SICEEP, ICC Hotel (SSD6166) – Response to Department of Planning and Infrastructure Submission

SICEEP, SICEEP ICC Hotel (SSD6116) – Response to City of Sydney Council

Typical Hotel Accommodation Plan

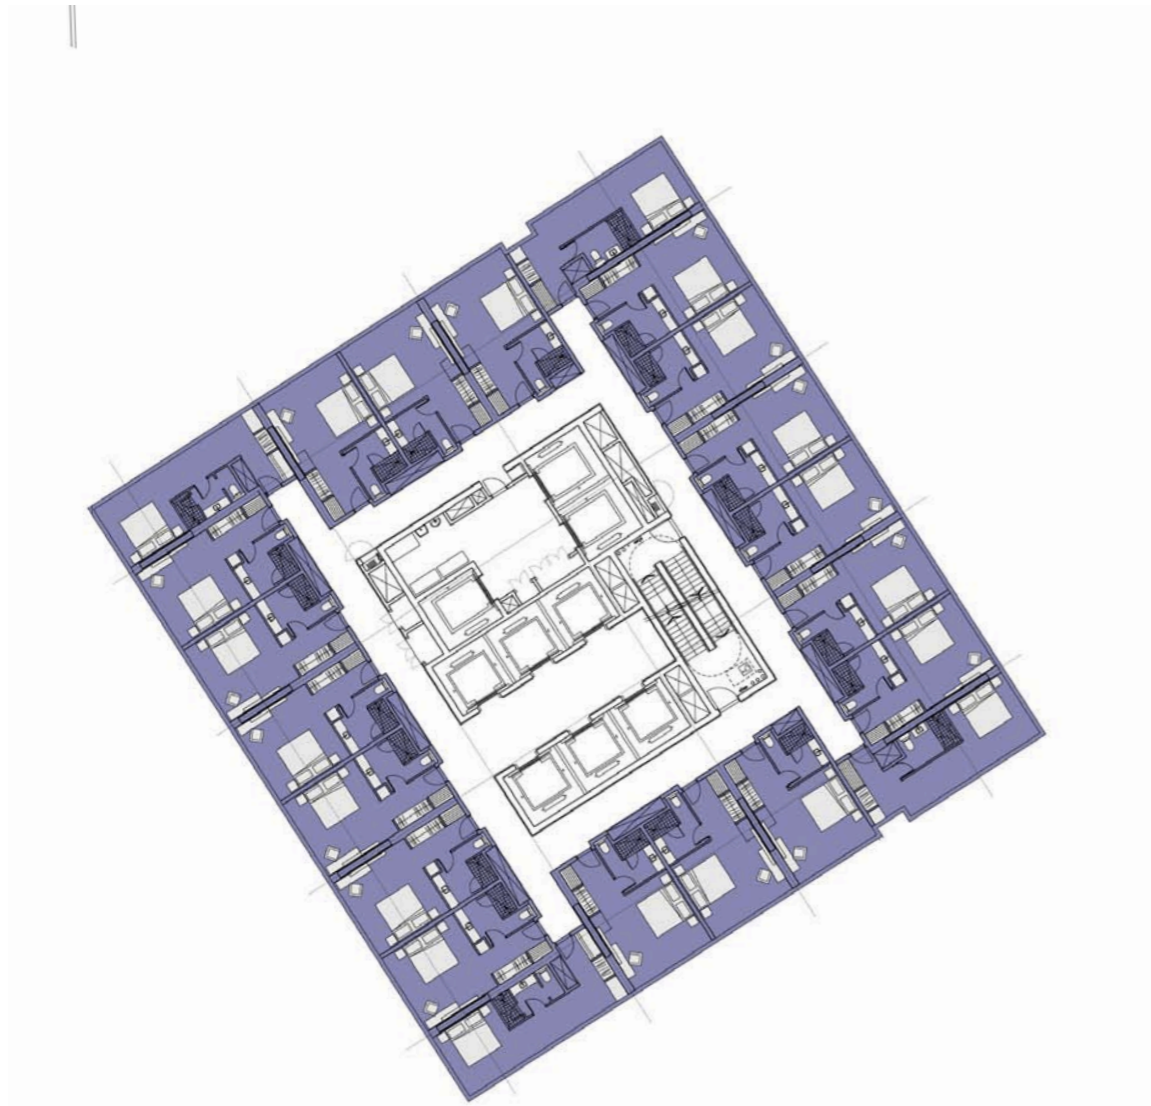
7. Consideration should be given to extending the internal circulation corridors to out to the face of the building to allow for access to natural light and ventilation.	The design of the hotel floor plate responds to a minimum room size required to achieve an appropriate quality of hotel accommodation to complement the SICEEP Core Facilities attractive to international travellers and domestic guests alike. By extending the internal corridors to the external face of the building the corner rooms would need to enlarge, thereby increasing the size and dimensions of the tower floorplate, which would impact on view sharing from buildings behind. The circulation corridors are to be designed to achieve a high quality indoor environment including direct and indirect lighting and the circulation space of this building will be mechanically ventilated to ensure a high indoor air quality.
Stormwater and flooding

Recommendation	Response
Recommendation 5: Extend the internal corridors of the hotel levels to the edge of the building.	The design of the hotel floor plate responds to a minimum room size required to achieve an appropriate quality of hotel accommodation to complement the SICEEP Core Facilities attractive to international travellers and domestic guests alike. By extending the internal corridors to the external face of the building the corner rooms would need to enlarge, thereby increasing the size and dimensions of the tower floorplate, which would impact on view sharing from buildings behind. The circulation corridors are to be designed to achieve a high quality indoor environment including direct and indirect lighting and the circulation space of this building will be mechanically ventilated to ensure a high indoor air quality.
Recommendation 6: In the event that the porte-cochere is not relocated to Darling Drive (as recommended), review the design to make it more functional and user-friendly.	The porte cochere will be the key arrival and departure point for the ICC Hotel, servicing guests and visitors, accessing the hotel on foot and by vehicle. As such the porte cochere will be designed to safely accommodate pedestrian and vehicular use. Harbourside Place and the ICC Hotel porte cochere area will be operated as a shared zone with a speed environment of up to 10kph, ensuring pedestrian priority and safety. Vehicular movement within the porte cochere area will be maintained by parking bays on either side and will be further constrained by kerbs which will be flush with hidden drainage in appropriate locations. Vehicles within the porte cochere drop off area from Harbourside Place will be alerted to a pedestrian interface through a change in surface materiality. The change in colour and shift in scale from a large size unit paver to a small scale cobble generates a subtle rumble in texture and sound which will assist in alerting attention to a change of environment. Similarly, pedestrians will be sensitive to vehicular circulation through the above mentioned materiality changes as well as the kerb step down from the hotel lobby onto the drop off zone. Further detailed design including sections and materials and finishes is provided in Appendix D Supplementary Public Domain Design Report and Plans.
